From: Amanda Scholes on behalf of Planning.Responses
Sent: 19 July 2018 09:42
To: Planning Scanning
Subject: FW: Sack Lane, Lidsey, West Sussex - Planning Application No. AL/60/18/DOC

Further drainage comments

From: Laura Gibbons
Sent: 17 July 2018 16:01
To: 'Stephen Penfold'
Cc: Simon Davis; 'Richard Atkinson'; 'Sue Frodsham'
Subject: RE: Sack Lane, Lidsey, West Sussex - Planning Application No. AL/60/18/DOC

The plans show that you are planning on attenuating surface water on site and then pumping this to discharge to the ditch, which is off site. Please investigate infiltrating surface water on site, i.e. use of a soakaway (set at least 5m away from any building) instead of the attenuation tank. If this is located appropriately it would remove the need for pumping and discharging to the ditch.

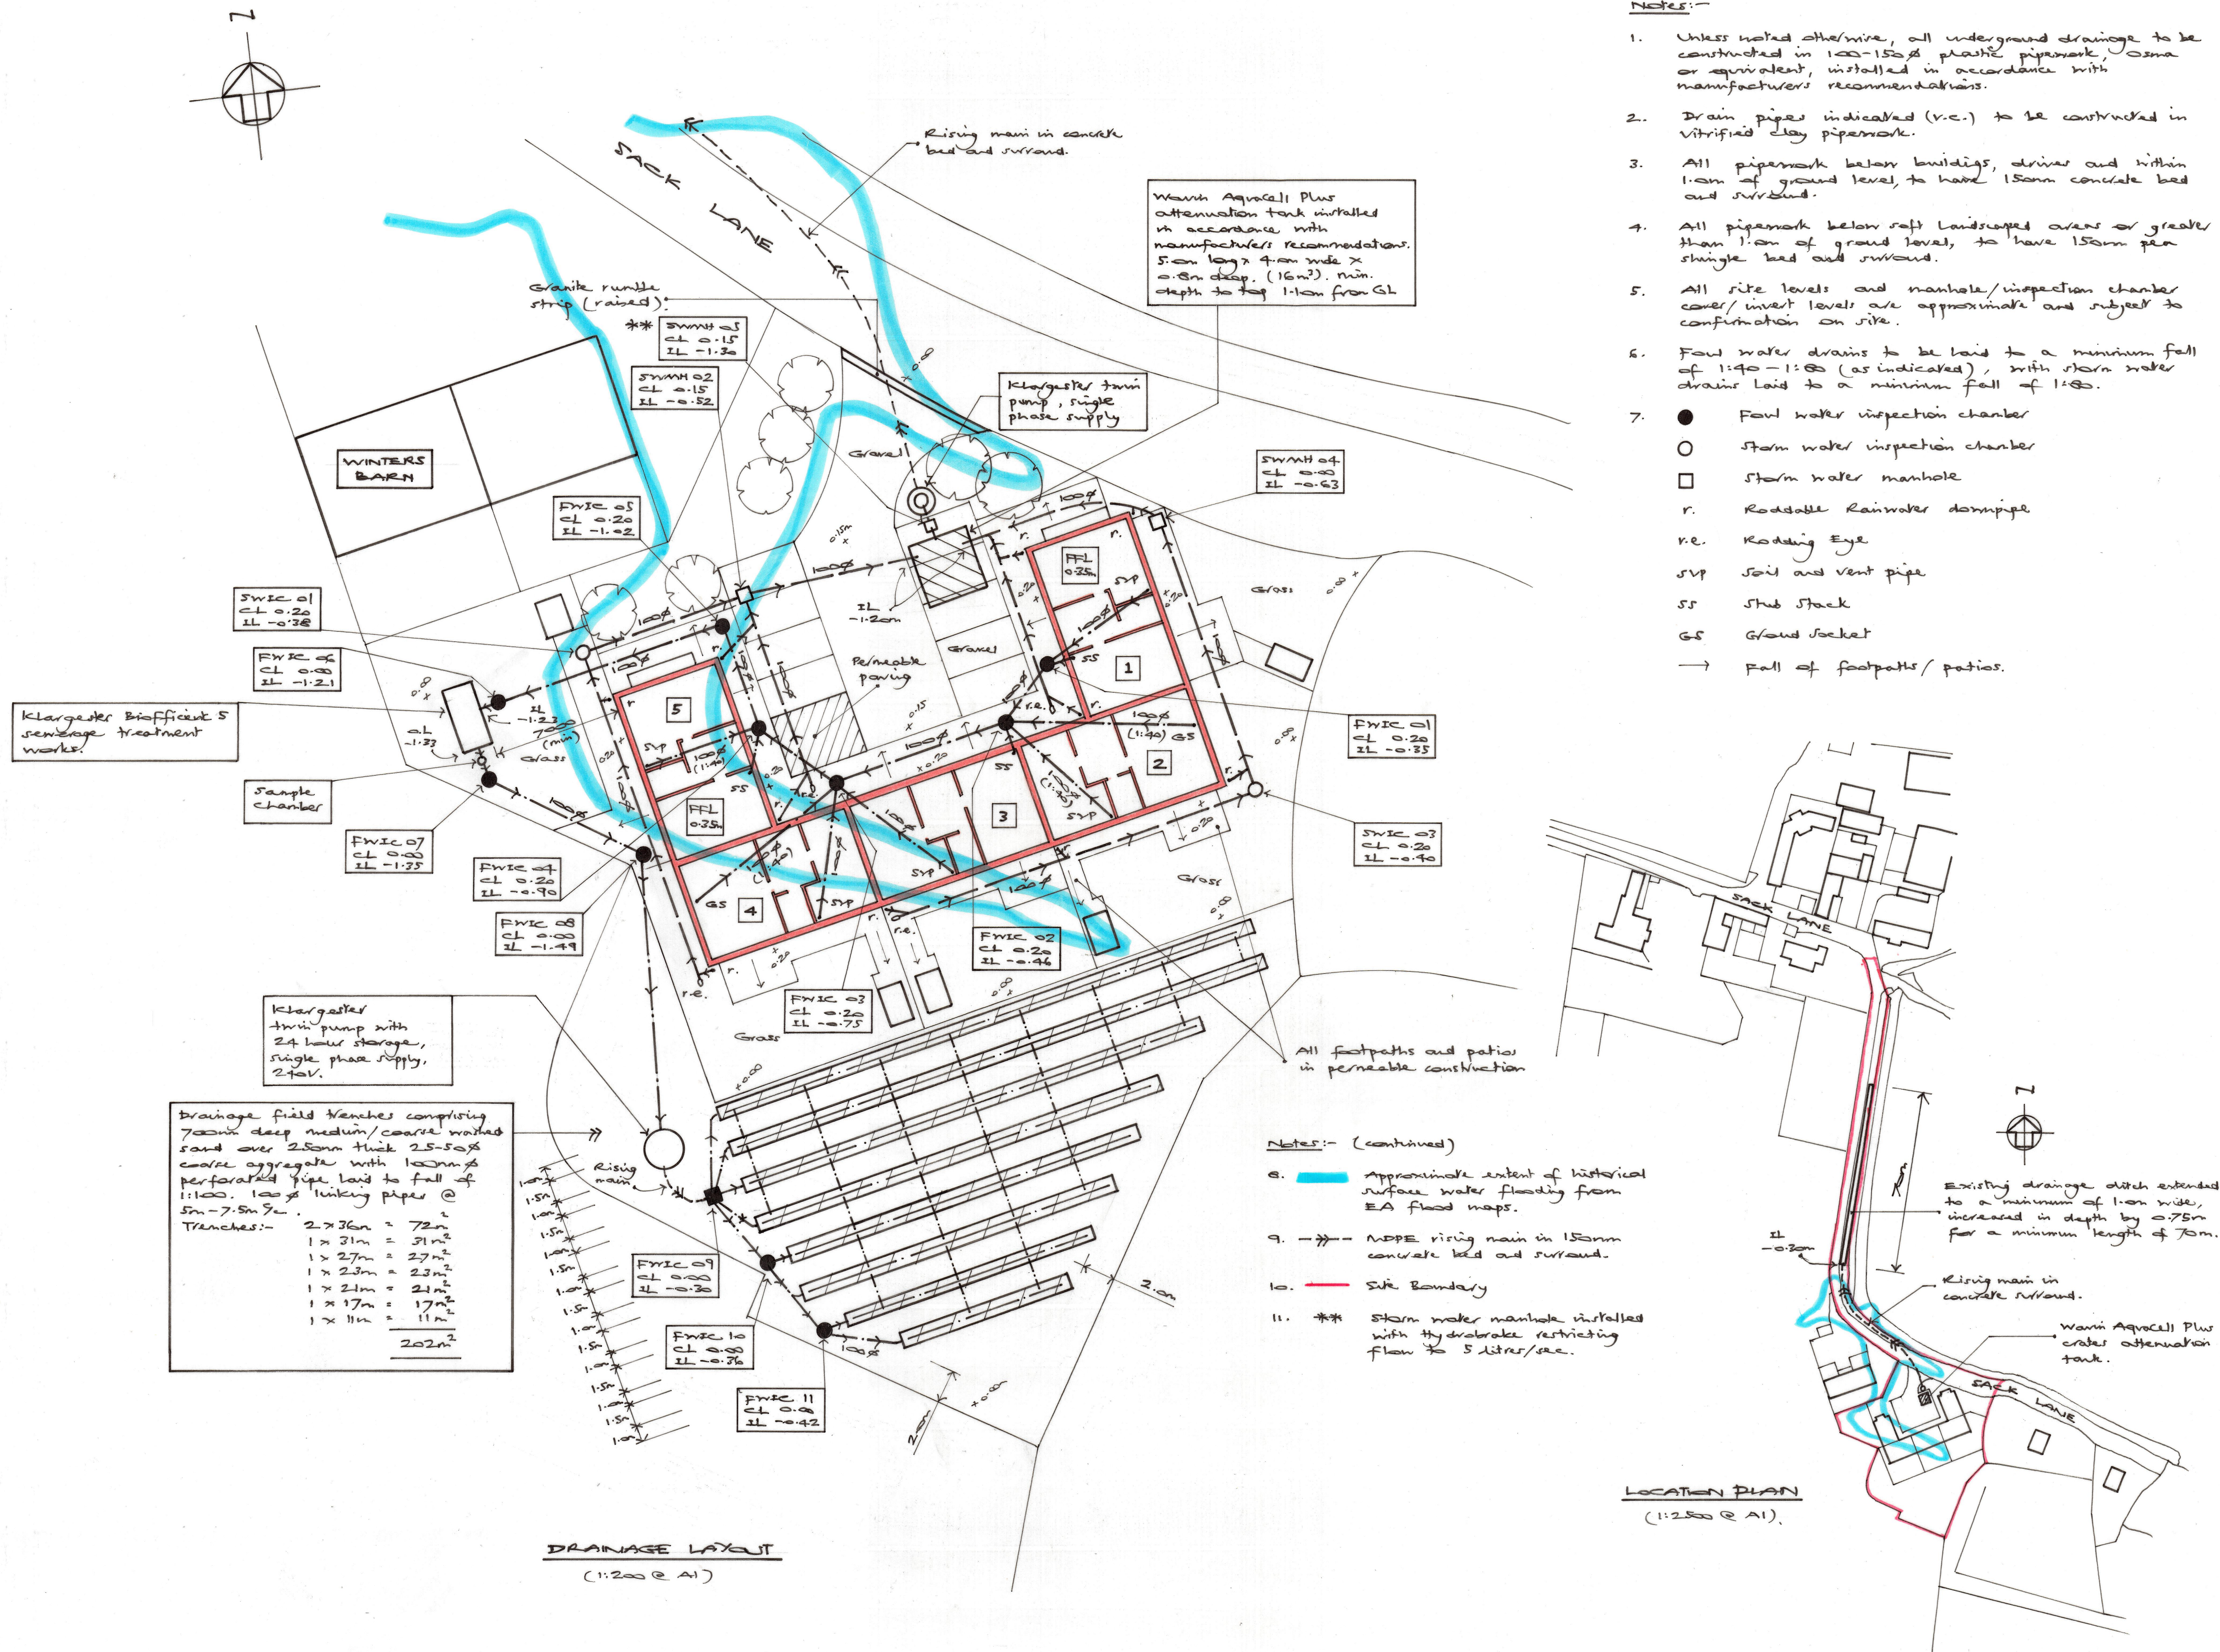
I note that the red line site boundary shown on the drainage layout plan is significantly different to that submitted as part of the original planning application. Please correct this on the drainage layout.

1. Neither ourselves or the applicant want install any pumps. The purpose of incorporating these is simply to raise the discharge levels above any elevated winter groundwater levels, which it will do.
2. Surface water is being discharged via infiltration through the drainage trench.
3. See below.
4. Surface water is controlled through a hydrobrake installed through manhole SWMH 05, limiting flow to 5 l/s, as stated on our drawing no. 18094/100'B'.

If monitoring indicates winter groundwater levels are very high, then we will have no option but to adopt the last resort of pumping, as indicated on our drawing no. 18094/100'B', as this is the only method to raise discharge levels above it. Similarly, if further winter infiltration testing shows the values used in the design submitted are too low, then the size of the drainage trench and drainage field can be increased within the site boundaries.
